Our Ref: LU/299/19/PL
Your Ref:

Town & Country Planning Act 1990 (as amended)
Town and Country Planning (Development Management Procedure) (England) Order 2015
Application for Planning Permission

Development Upgrade of football pitch floodlights.
Location Littlehampton Town Football Club The Sportsfield St Flora's Road Littlehampton

Title			Location Plan		
Scale	1:1250	At original	A4	© Robert Clark Associates Ltd	
Drawing Number	2101/L1			Revision	-

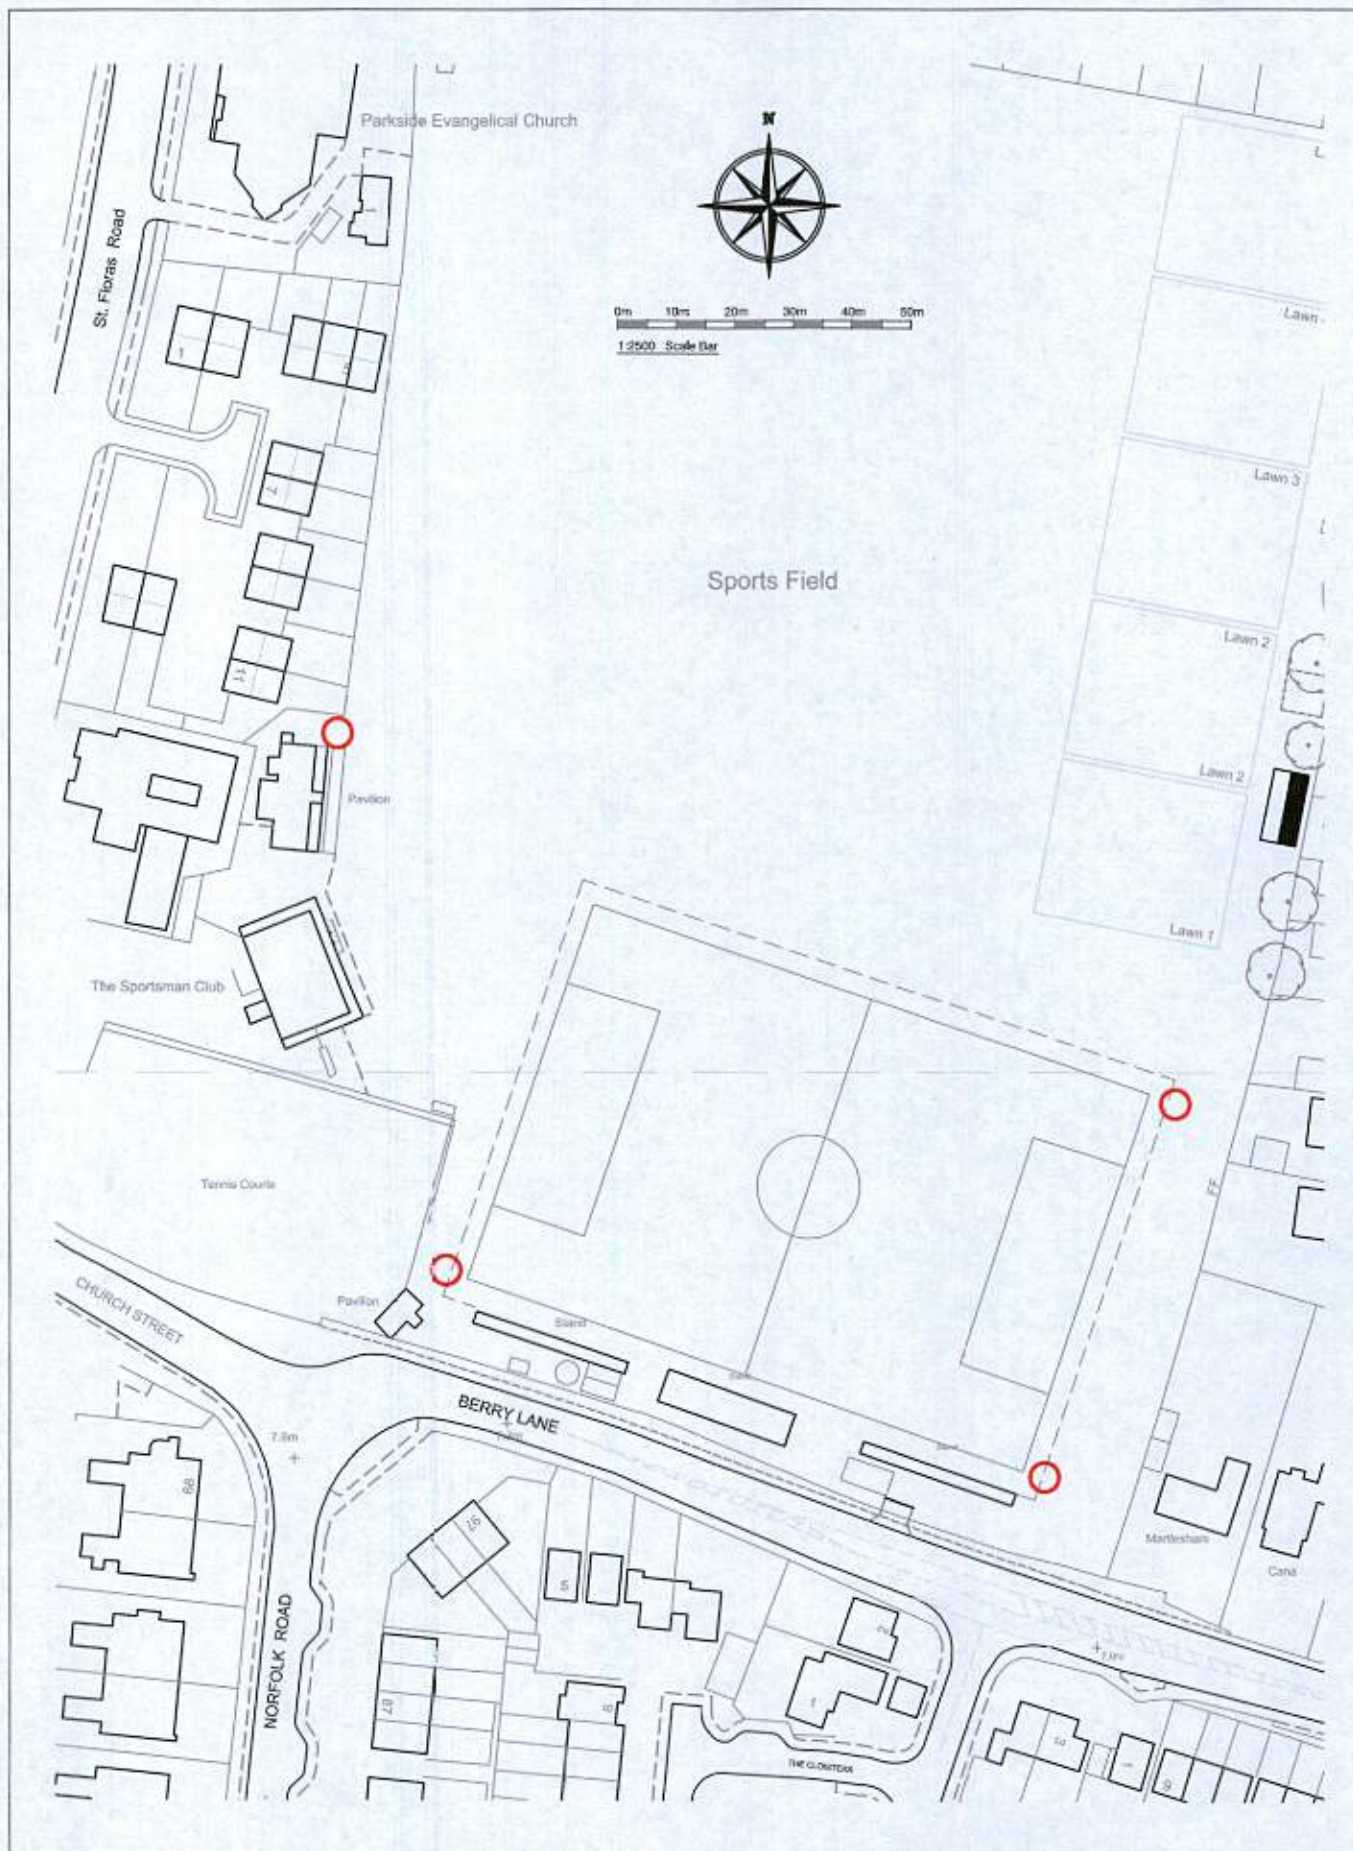
Please submit 1 electronic or 3 paper copies of an amended location plan at a scale of 1:1250 or 1:2500 for rural areas showing the site area edged in red & any other land owned edged in blue.
